CITY OF MERCER ISLAND

STAFF REPORT & RECOMMENDATION TO HEARING EXAMINER REASONABLE USE EXCEPTION AND ZONING VARIANCE

Project Nos:	CAO15-001 & VAR18-002
Description:	<p>The Applicant has revised a Reasonable Use Exception (CAO15-001) and has applied for a Variance (VAR18-002), to construct a proposed house and associated improvements at 5637 East Mercer Way.</p> <p>The proposed house and improvements will be located within a wetland, wetland buffer, and stream buffer, which is the basis for the Reasonable Use Exception (RUE) application. The proposed house is located within a required setback from an easement in order to reduce impacts to environmentally critical areas, which is the basis for the proposed Variance.</p>
Recommendation:	Reasonable Use Exception – Approve with Conditions Variance – Approve
Applicant/ Owner:	MI Treehouse, LLC (c/o Bill Summers)
Site Address:	5637 East Mercer Way, Mercer Island, WA, 98040; Identified by King County Assessor tax parcel number 1924059312
Zoning District:	R-15
Project Contact:	Claire Hoffman, Planner, Environmental Science Associates (ESA)

SITE PLAN
5637 MERCER WAY
MI TREEHOUSE, LLC
 11030 SE 30TH ST
 BELLEVUE, WA 98004

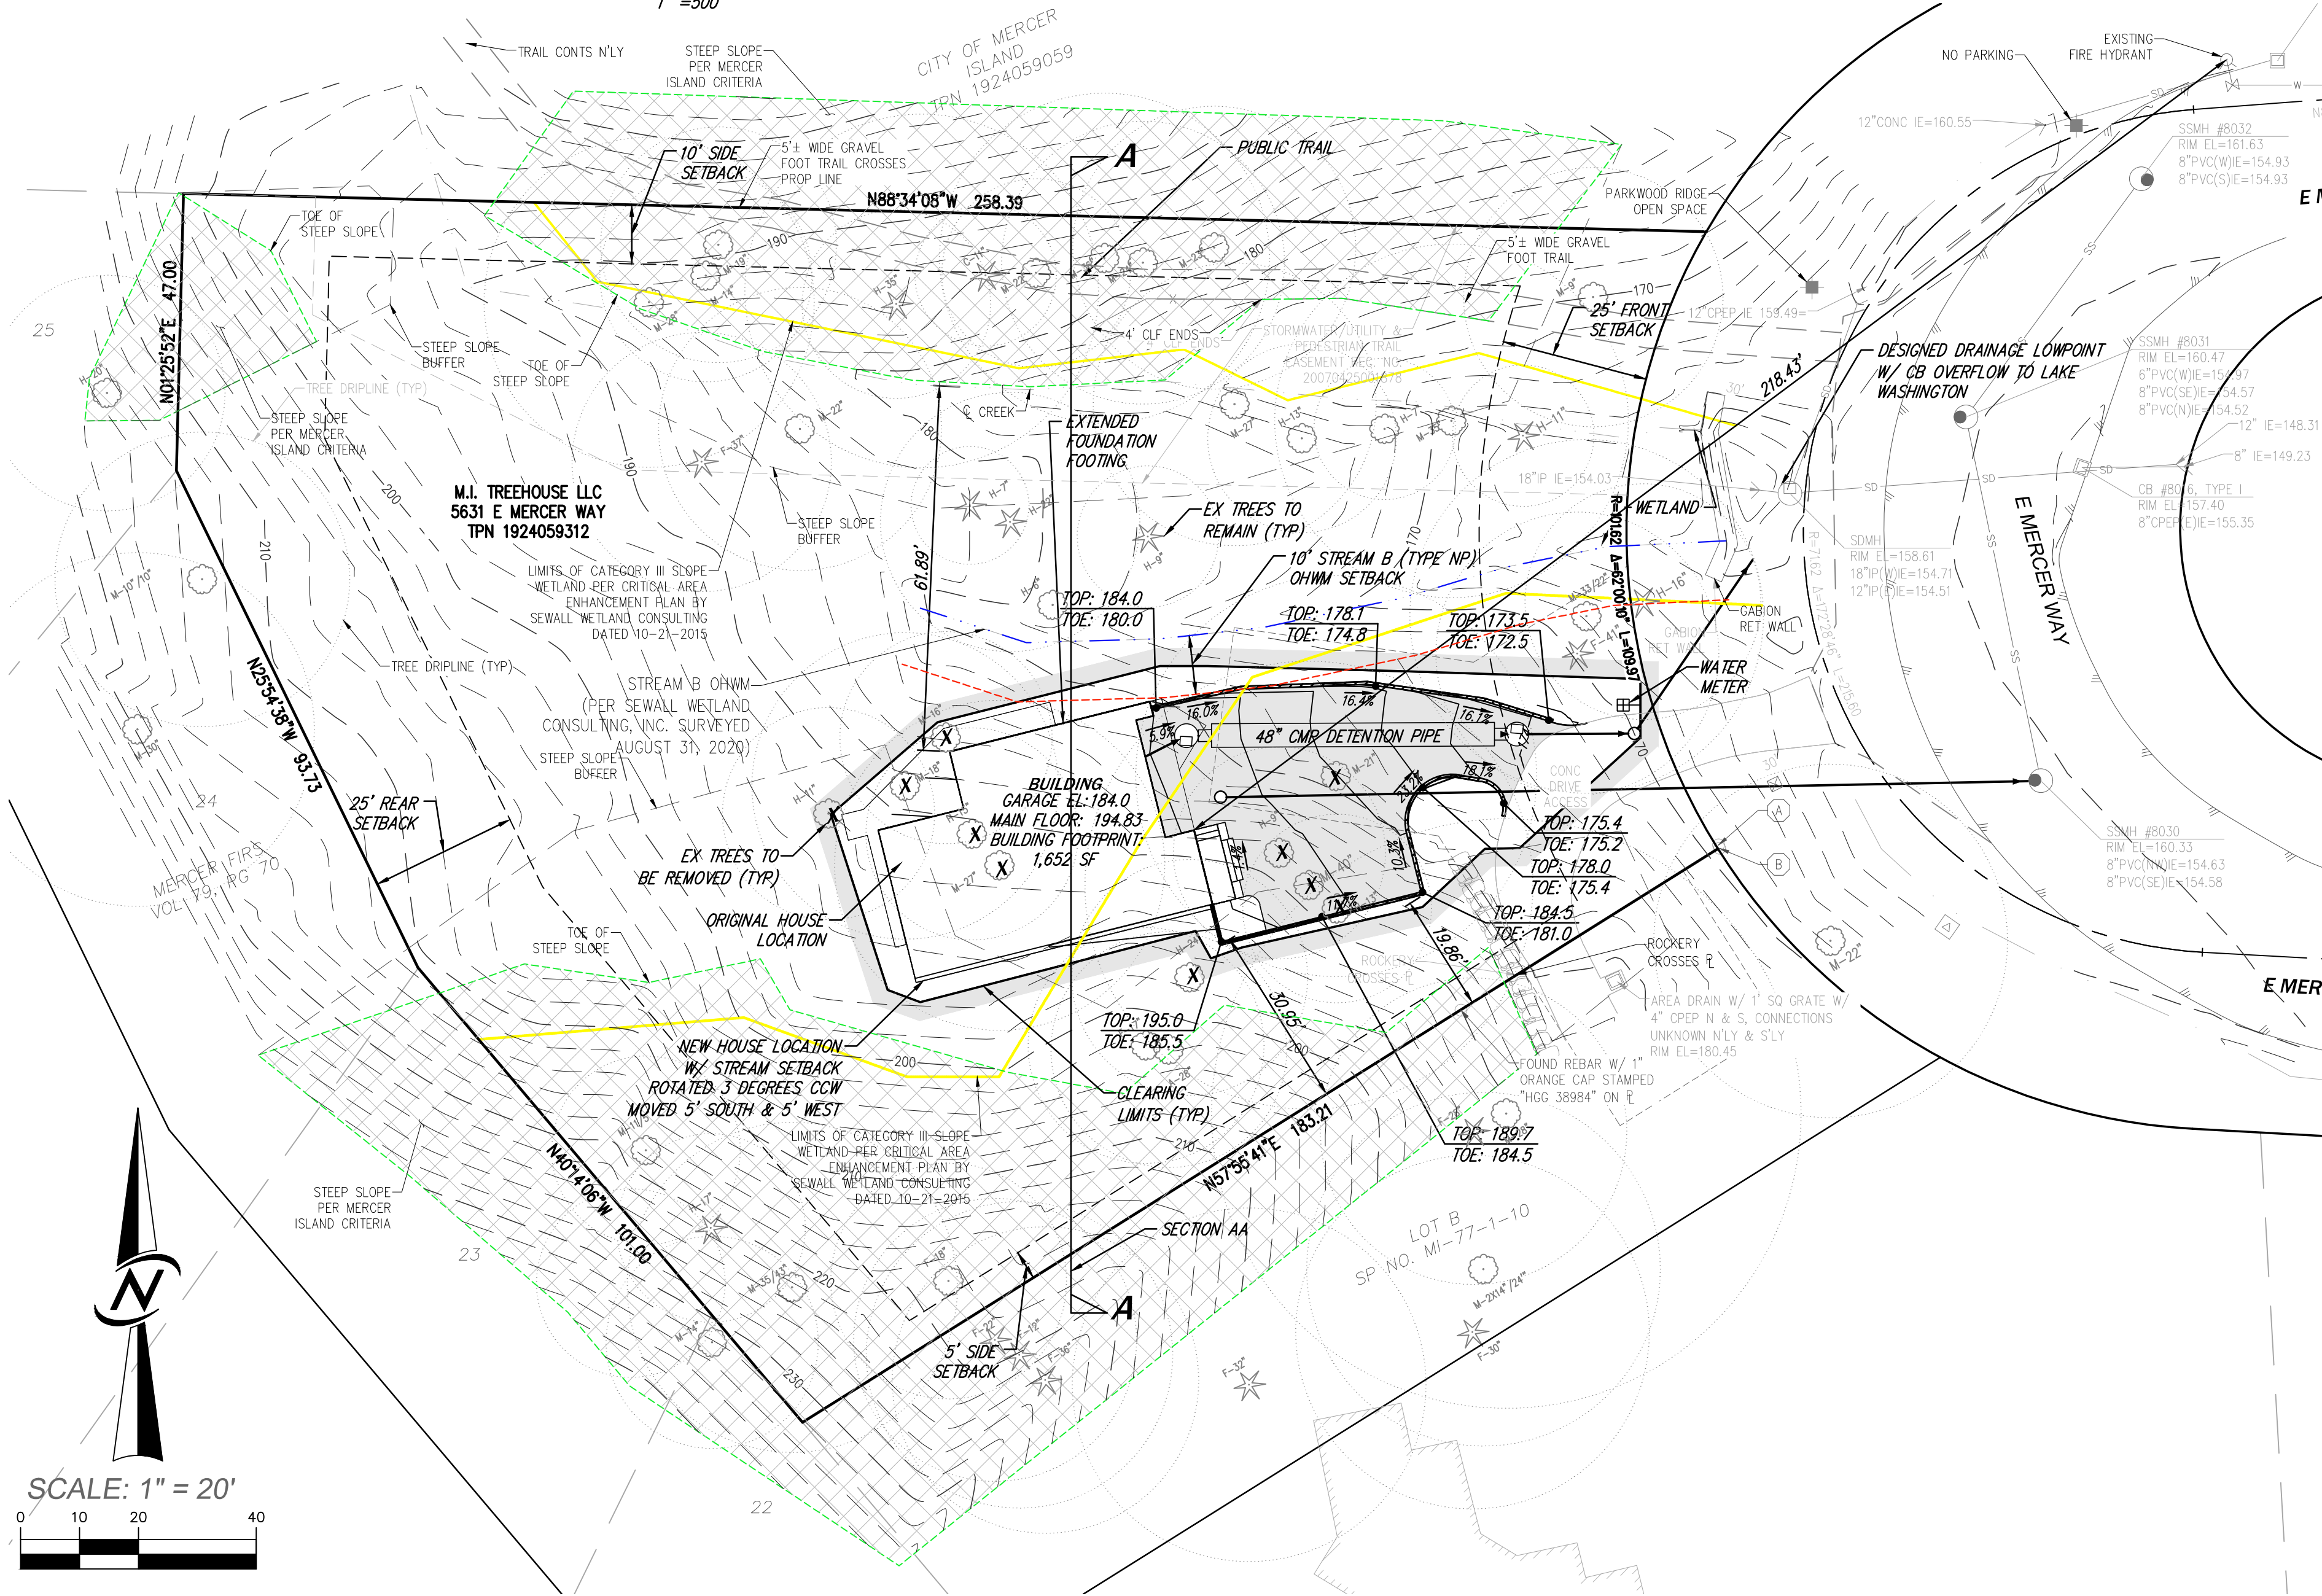
- b. The western property line was incorrectly drawn (Finding 1, footnote 6);
The western boundary issue has been resolved on all applicable plan sheets (C1.01, C1.02, C2.01, C4.01, and "Site Plan" Sheets 1 of 2 and 2 of 2) (Exhibits 84 and 87b).

- c. All recorded easements that encumber the property (Finding 46) should be shown; including the Permanent Stormwater/Utility and Pedestrian Trail Easement (the "2007 Easement") (Finding 25) and the 1978 recorded side sewer easement (Finding 20, footnote 14) which were not included on the previous plan set;
A Stormwater/utility & Pedestrian Trail Easement Rec No 20070425001878 is shown on Sheets C1.01, C1.02, C2.01, and C4.01 (Exhibits 84 and 87b).
The applicant provided documentation supporting that the 1978 side sewer easement is likely included in error on the Title Report Restrictions and is referenced on a different plat (Exhibits 87a and 87c).

- d. The Fir tree referred to in Condition 2 of the Sunrise Ridge short plat is not accurately shown (Finding 19 and Conclusion 4);
Tree # 986 was identified by the applicant's arborist (Exhibit 90) and is shown on the site plan and Sheets C2.02 and C4.01 (Exhibits 84 and 87b) as F-41 (fir, 41-inch diameter at breast height [DBH]).

- e. Legend in on Site Plan does not match the figure (patterns in the legend that are not shown on the site plan and patterns on the site plan that are not in the legend) (Conclusion 4);
The legend on the site plan matches the figure (Exhibit 87b) are understandable and mostly match the sheets;

- f. Topography of the Site Plan is incorrect and does not comply with City requirements for RUE site plans (Finding 15 and Conclusions 4 and 8);
The topography has been updated on Sheets C1.01, C1.02, C2.01, and C4.01 and "Site Plan" Sheets (Exhibits 84 and 87b) to 2-foot contours and extended beyond the property line; however, the contours do not extend to 50 feet beyond the property as required for RUE site plans (Exhibit 75a). The applicant has made a reasonable effort to extend contours onto adjacent properties without trespassing (Exhibit 87a).

- h. The location of Stream B is not correct; it's should be verified and the building be set back at least 10-foot from the watercourse (Findings 14, 15, 36, and 39, and Conclusions 4 and 5); *Stream B was reflagged by the Sewall Wetland Consulting (Sewall), surveyed, and included on the updated survey and site plan (Exhibit 80f and 87b). The footprint of the house was moved to 10 feet from the OHWM of Stream B. The applicant stated they would update the plan set when review of building permit resumes (Exhibit 87a).*
